Review of Response to Council Submission

80-88 Regent Street, Redfern – SSD 7080

City of Sydney – Submission to Revised RTS November 2016

1 East Elevation
1 : 200@A1

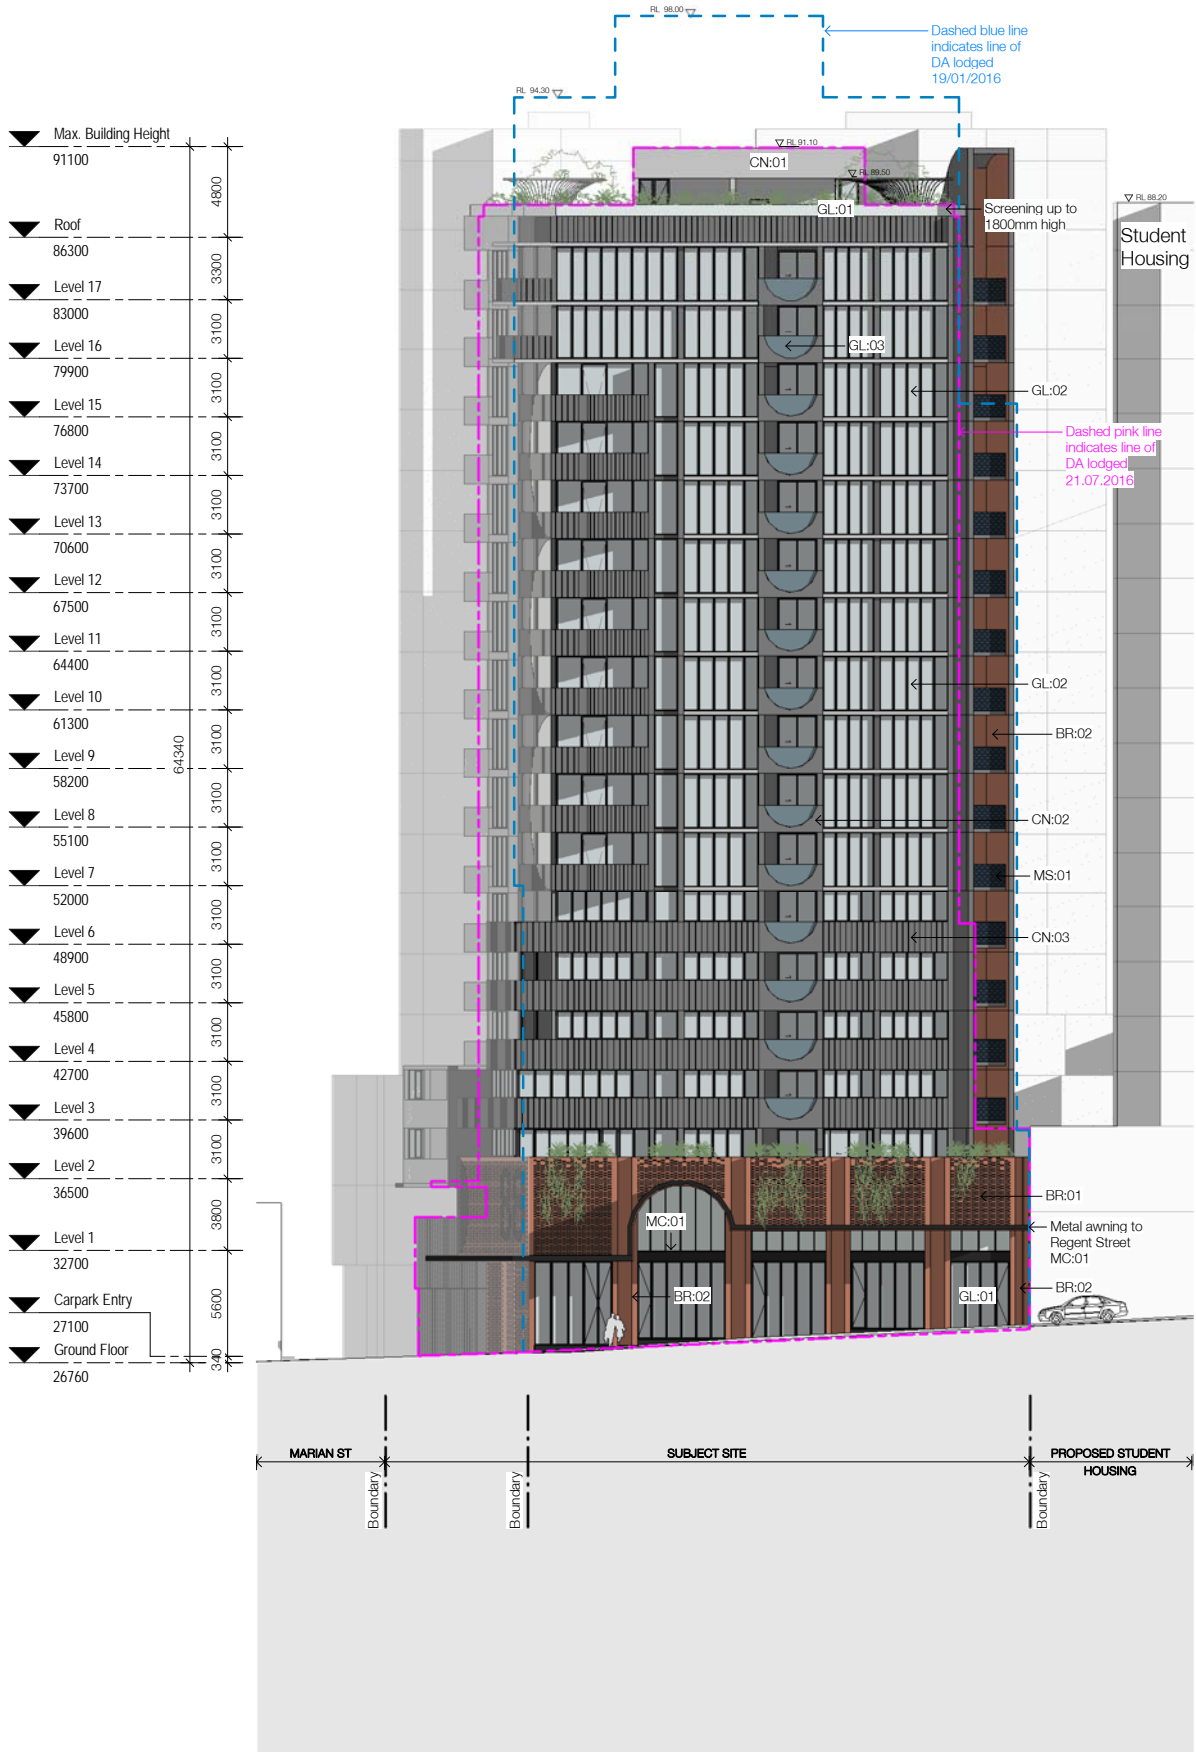
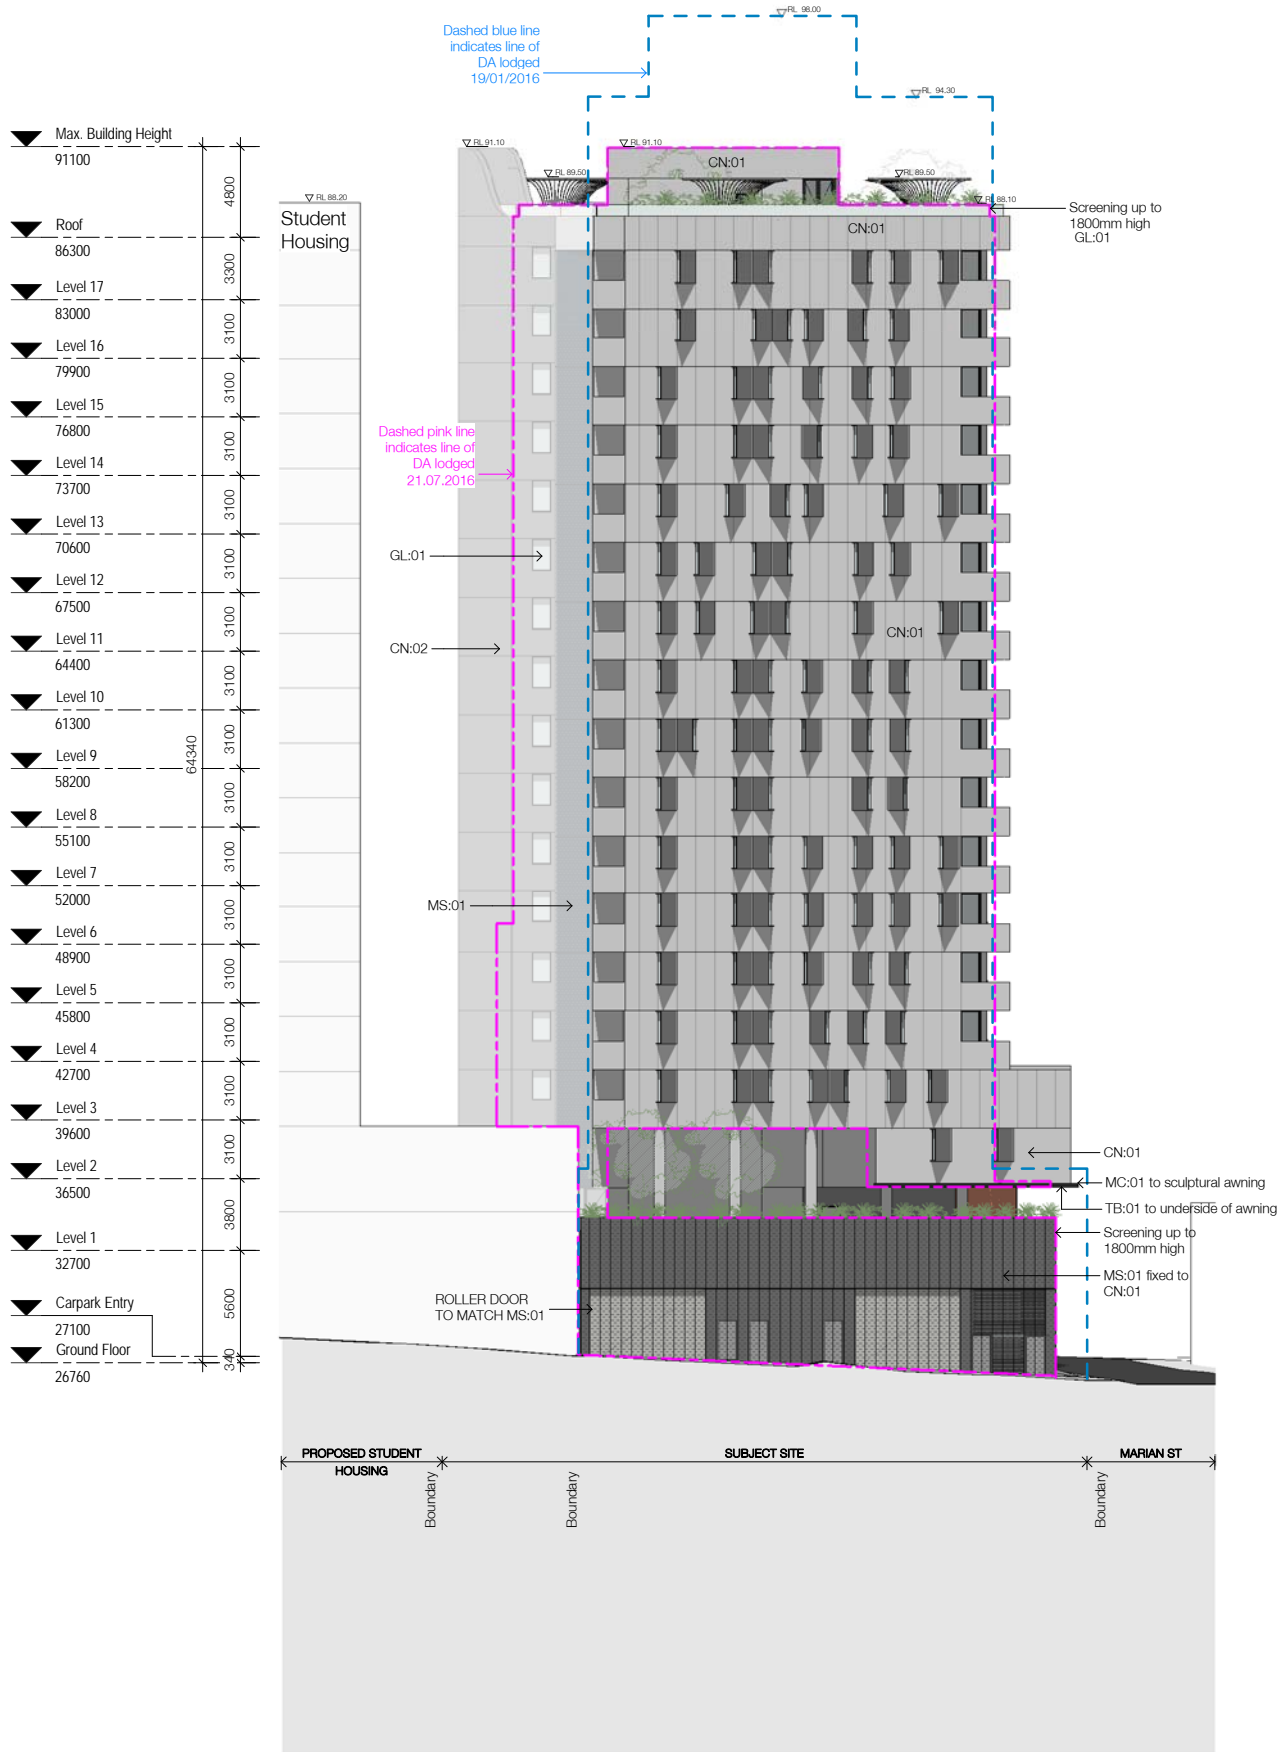
Matter	Particulars of Issues	Revised RTS Response	Location in Report
Natural cross ventilation	<i>The Regent Street elevations show floor to ceiling glass to bedrooms and living rooms. It is not clear how these rooms achieve natural ventilation in accordance with the ADG as no window types have been shown.</i>	All apartments are corner, dual aspect and naturally cross ventilated.	Refer to Attachment 1 and Section 4.8.2
Setbacks and Separation	<i>Non-compliance with setback at corner Marian and Regent Streets. More rather than less footpath is required at corners as it is a natural congregation point for pedestrians.</i>	The 1.5m ground level setback has been provided for the entire Marian Street frontage and no longer narrows at the corner.	Refer to Attachment 1 and Section 4.2.2
	<i>It is unclear if the 1.4m setback to Marian Street will be dedicated to Council or if it is an extension of the footpath within private land. It is necessary to understand the purpose of this setback as Level 2 and 3 encroach into this setback area.</i>	The additional 1.5m setback provides an extension to the width of the existing footpath, however this section of the footpath will remain part of the site, and will not to be dedicated to Council. This is consistent with the existing arrangement for the footpath widening in front of 7-9 Gibbons.	Refer to Attachment 1 and Section 4.2.2

01 Winter 9am Existing
0501 1 : 1000@A1

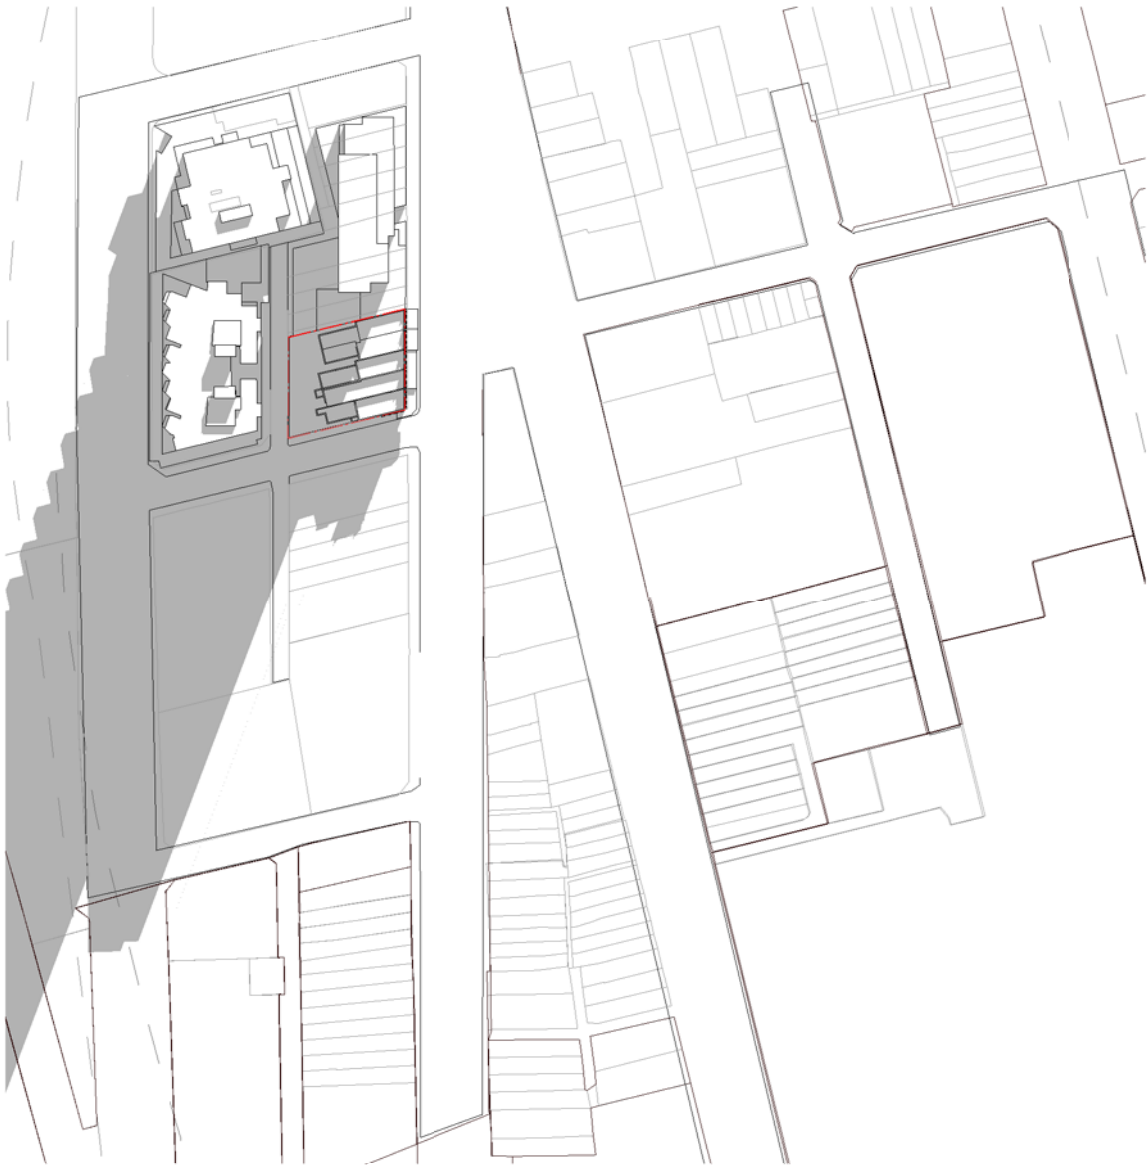
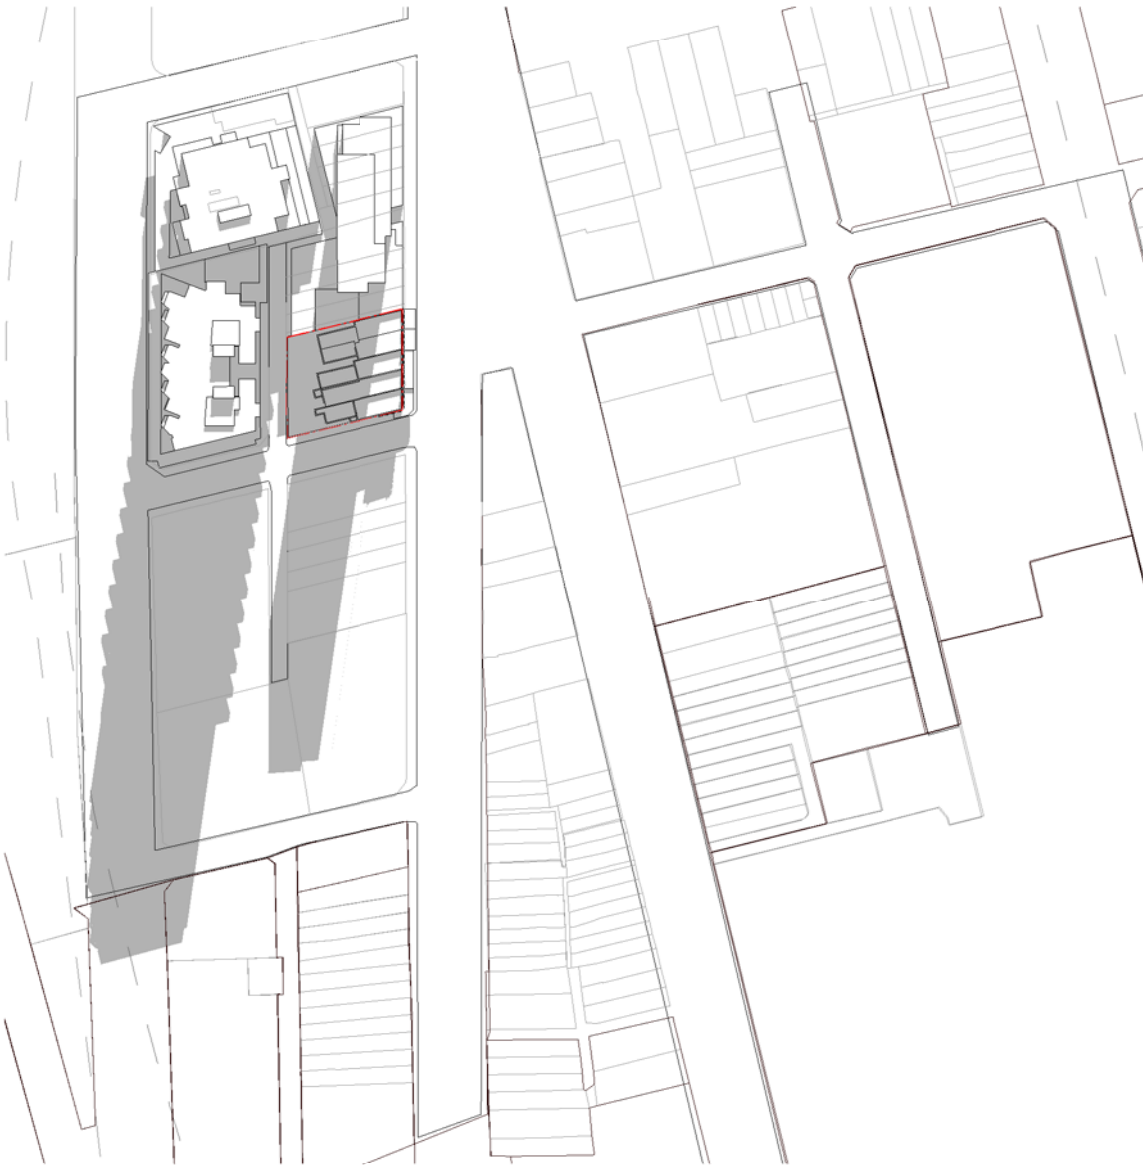
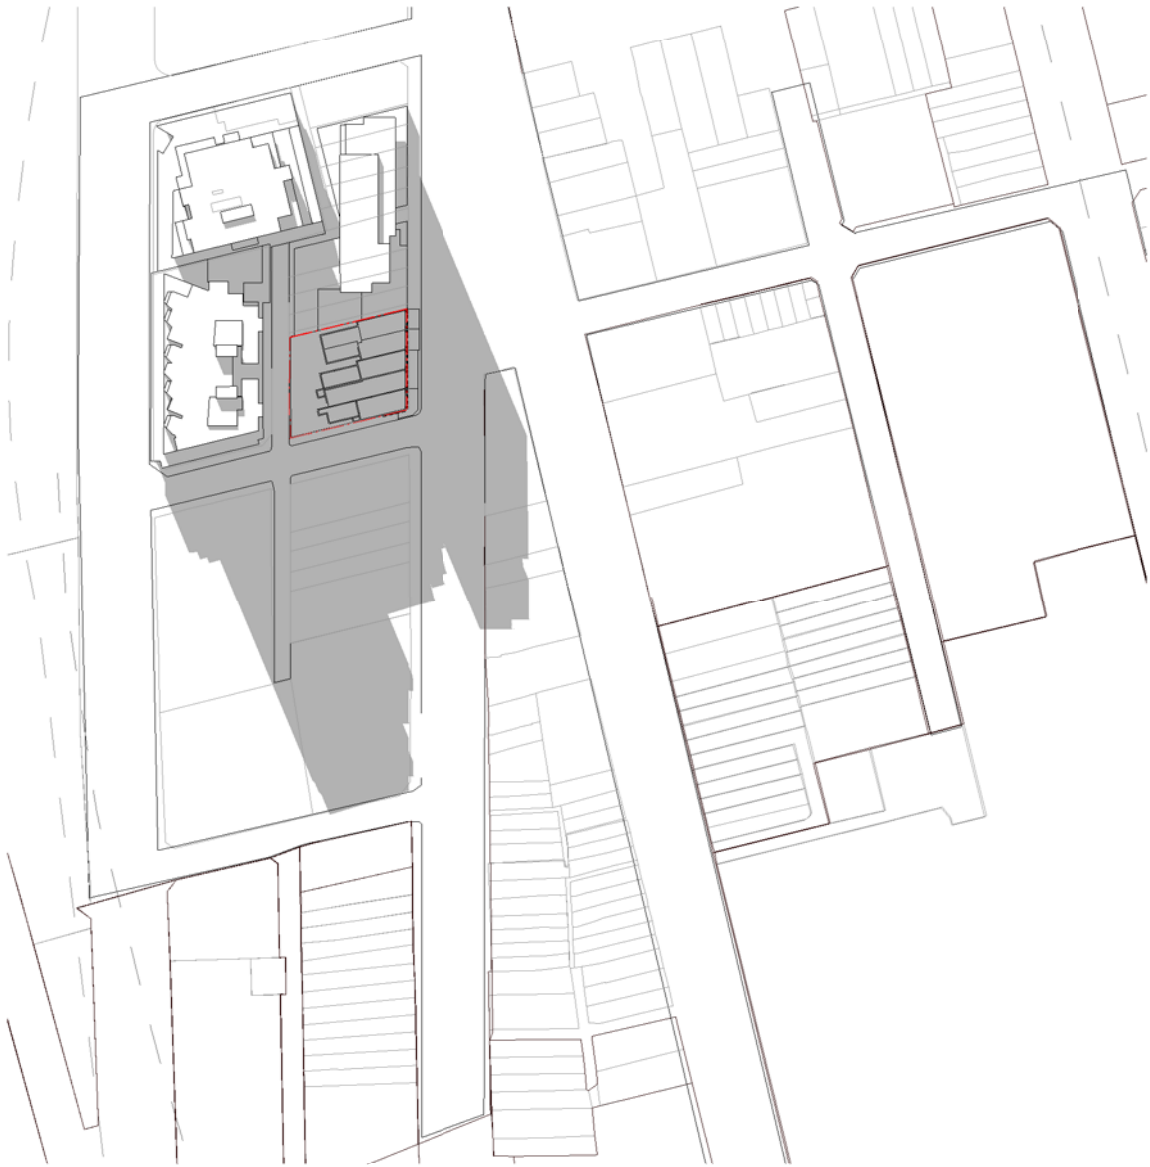
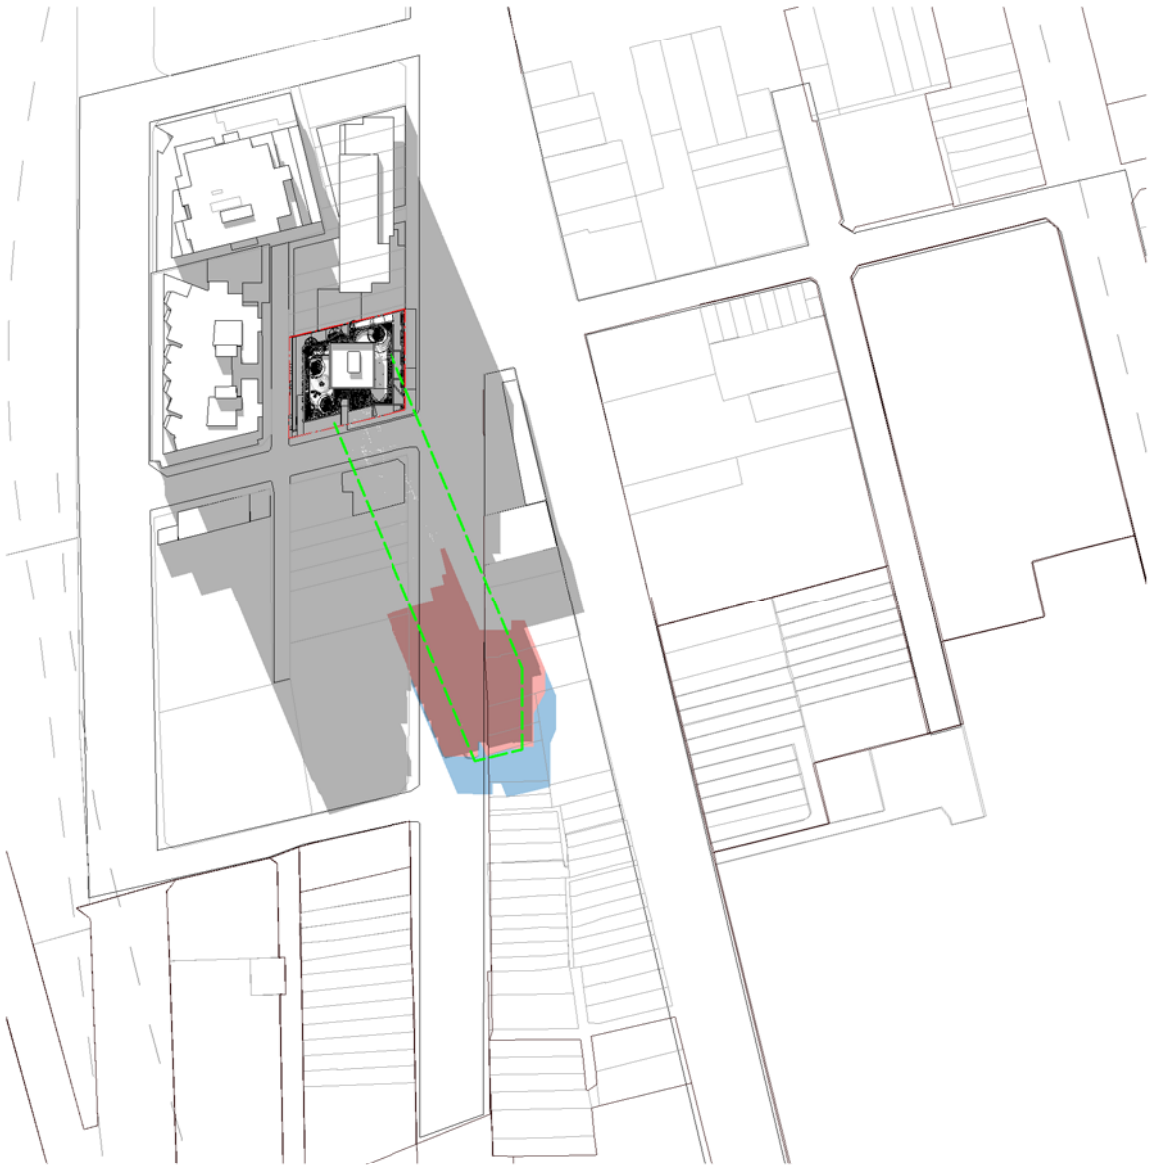
<i>The shadow diagrams are unclear in demonstrating the extent of the shadow cast by the current proposal. A shadow diagram illustrating a compliant 8-storey scheme and the proposed 18-storey proposal should be prepared.</i>	Revised shadow diagrams have been prepared and are included in the Architectural Drawing package. The shadow diagrams show the shadow impacts of the proposal compared to the earlier schemes. A compliant scheme has also been shown, which is an 18 storey building as is permitted under the SEPP SSP with compliant 4m tower setback to Marian Street.	Refer to Attachment 1 and Section 4.8.2
	<i>The proposal will overshadow residential apartments at 1 Margaret Street and Gibbons Street Park. A detailed shadow diagram should be prepared illustrating the shadows cast on winter solstice for both sites, in addition to elevational shadow diagrams for residential apartments.</i>	At 9:00am there is a small amount of additional overshadowing at the southern-most tip of the Gibbons Street Park. By 10:00am the shadow has moved from the park. There is potential additional overshadowing to the residential apartments at Margaret Street. By 11:00am the proposal does not shadow these apartments.	Refer to Attachment 1 and Section 4.8.2
